**Our Case Number:** ABP-316119-23

**Re:** DART+ South West Electrified Heavy Railway Order - Hazelhatch & Celbridge Station to Heuston Station,  
and Hesuton Station to Glasnevin  
County Dublin and County Kildare

Subject: Objection to Irish Rail Dart & South West Map 16 Schedule of Works 16.10

Plan No. WORKS LAYOUT PLAN No. 16

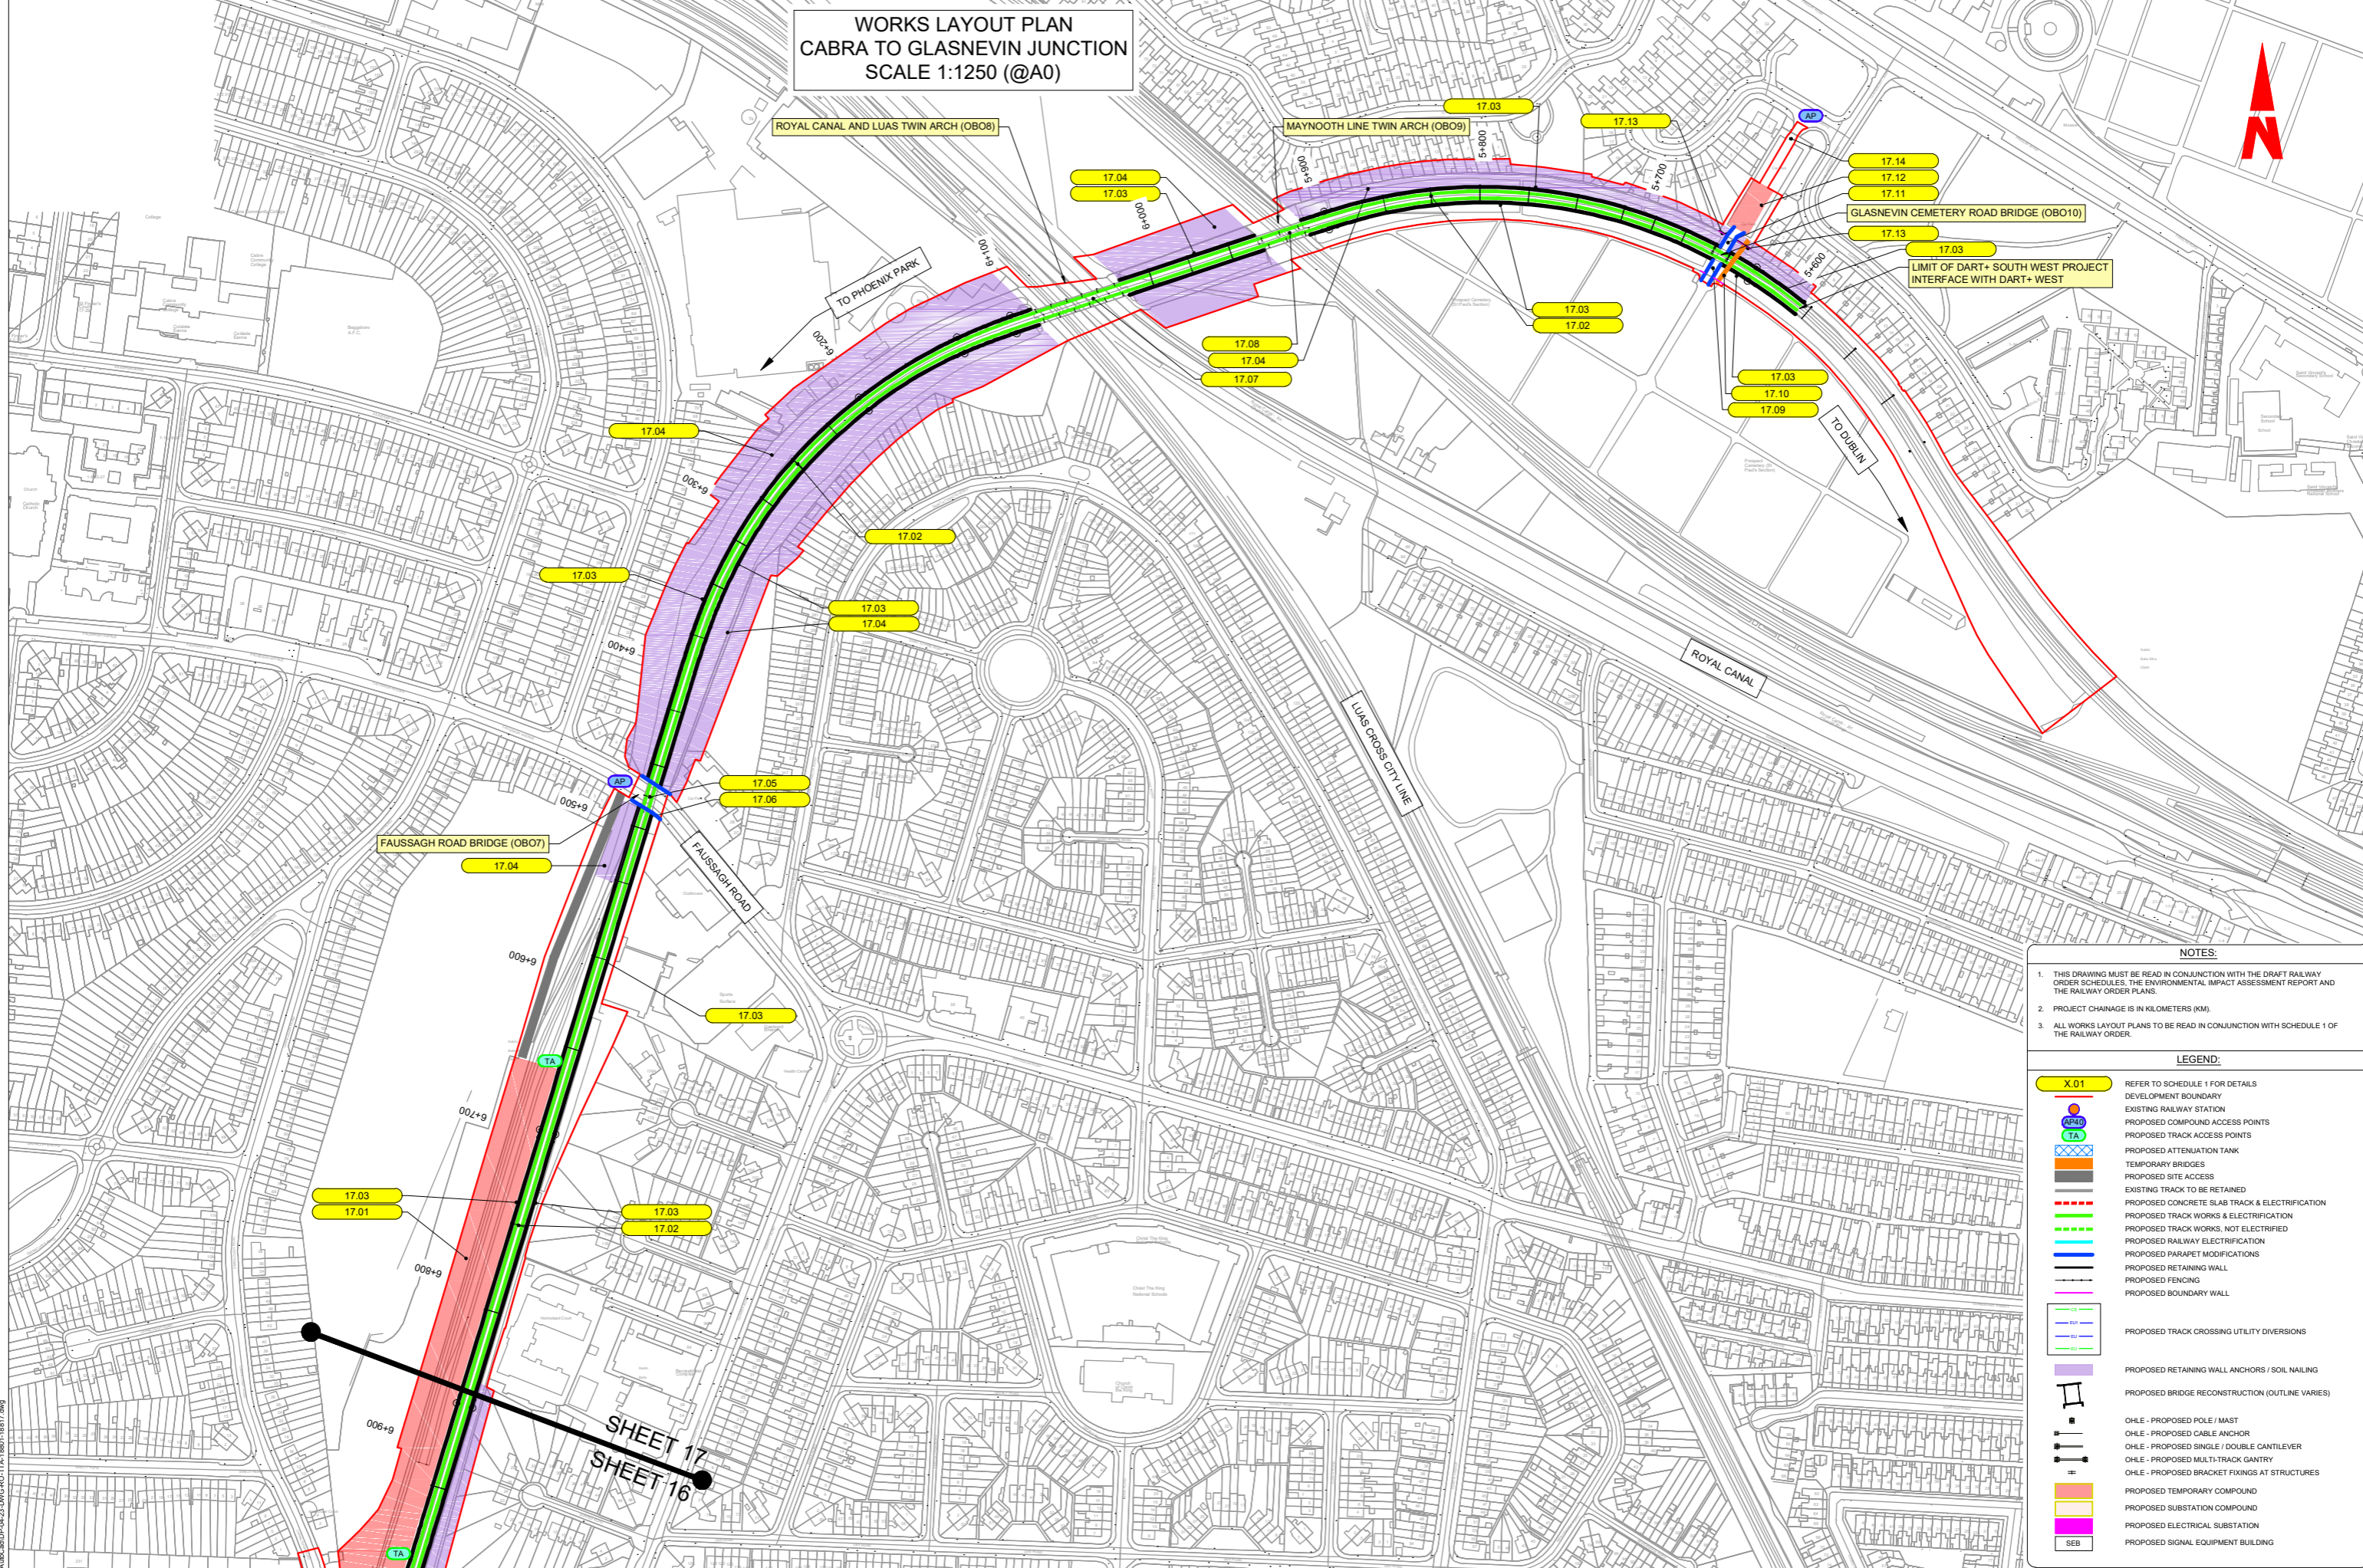
I am writing to formally lodge my objection to the proposed schedule of works 16.10 of the Irish Rail Dart & South West Map 16.

‘Construct of palisade fence on top of an existing low level masonry boundary wall’ works will also include localised repairs to the existing wall’.

As this wall is directly at the back of my property this personally affects us and all the current residents of Glenbeigh road with access to this area.

We do not see any security issues with the land as currently it is not a security issue. The lane way access to area in question is long secured by large black gates at each end and only the residents with properties contained in the space have access. The gated access have and continues to provide security to this area.

If a further fence is required we would request that it is 5 meters further towards the Irish Rail Line. This will protect the much loved and utilised space by residents.
